Application No: FG/94/20/HH
Site Address: 7 Little Drive Ferring BN12 5RF
Description of works: Conversion of roofspace to habitable use and conversion of roof from hip to gable end and single storey rear extension.

Thank you for your internet representation made on 14th September 2020 which has been recorded as an objection with the comments as follows:

FIRST FLOOR PLAN.

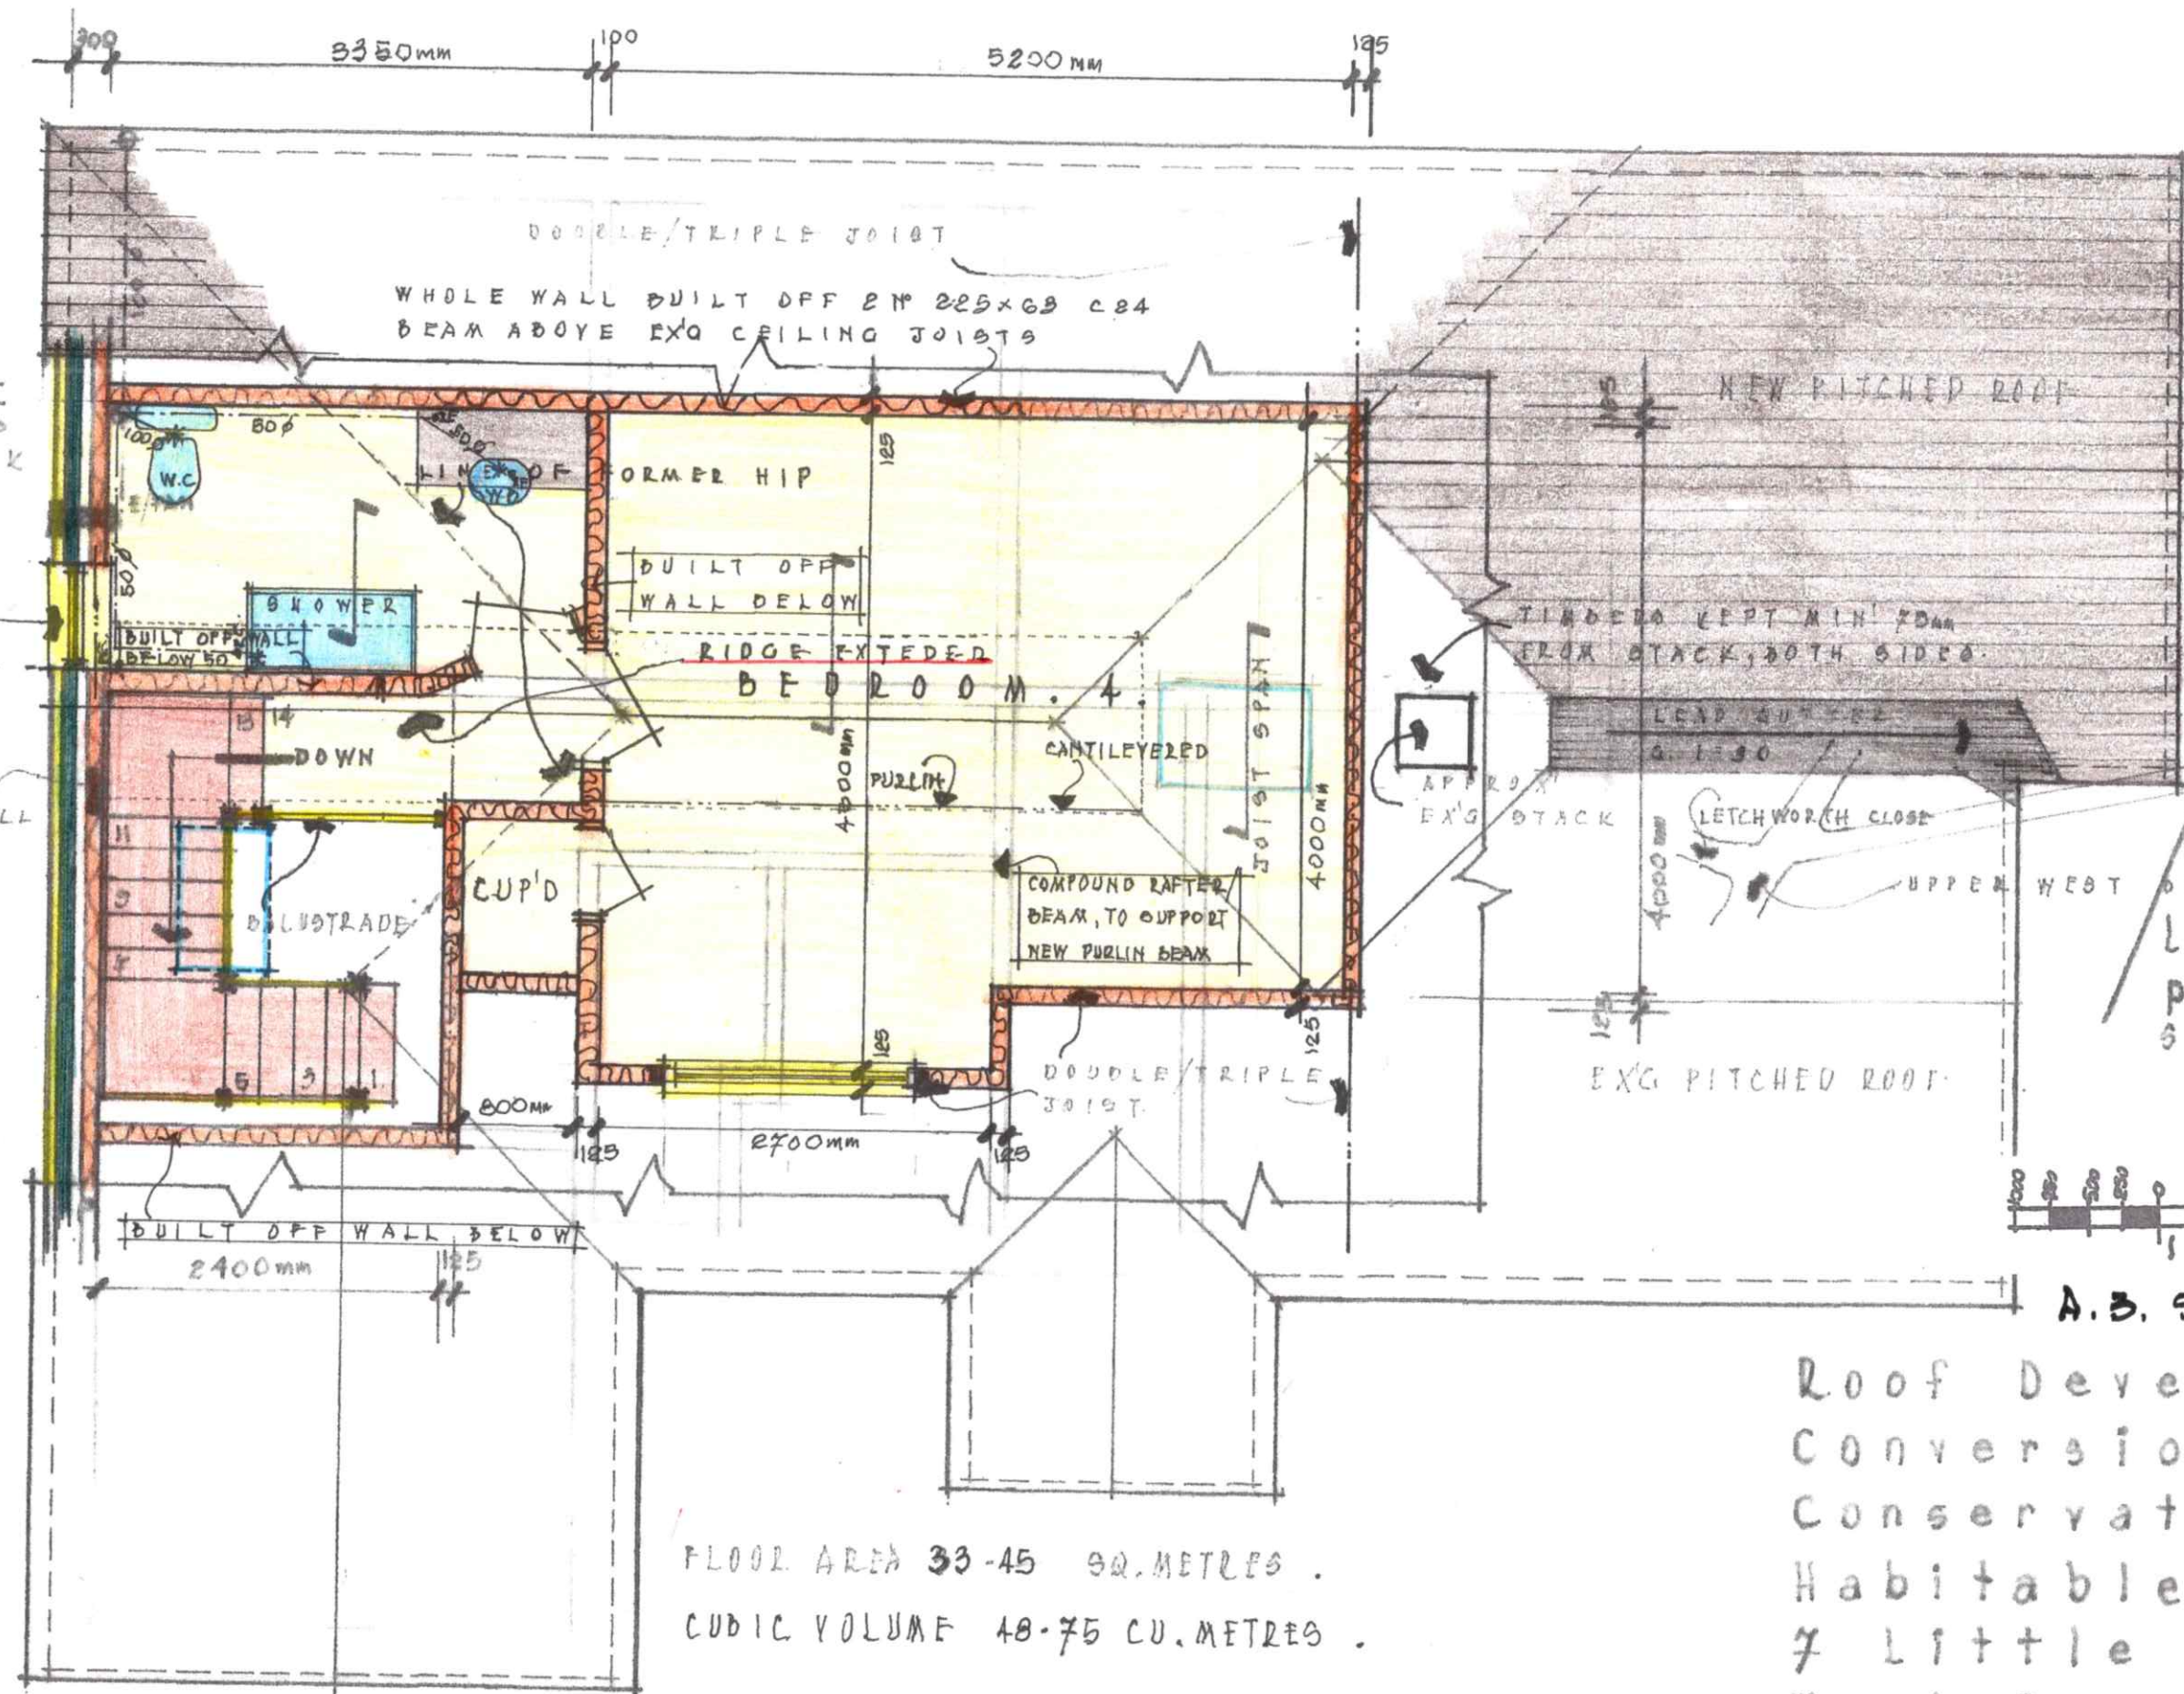
Please accept our formal objection to the planning application FG/94/20/HH. we live at 14 Upper West Drive with our back garden being opposite 7 Little Drive. Our garden is currently not overlooked as all surrounding properties are only ground level. If the application for 7 Little Drive is accepted a 1st floor dormer window will be able to look over our garden and conservatory and impact our privacy. We have lived here over 20 years and have always valued our privacy is one of the main reason we bought the property in the 1st place. We hope you will consider our objection. Yours Sincerely Mr & Mrs I F Scott
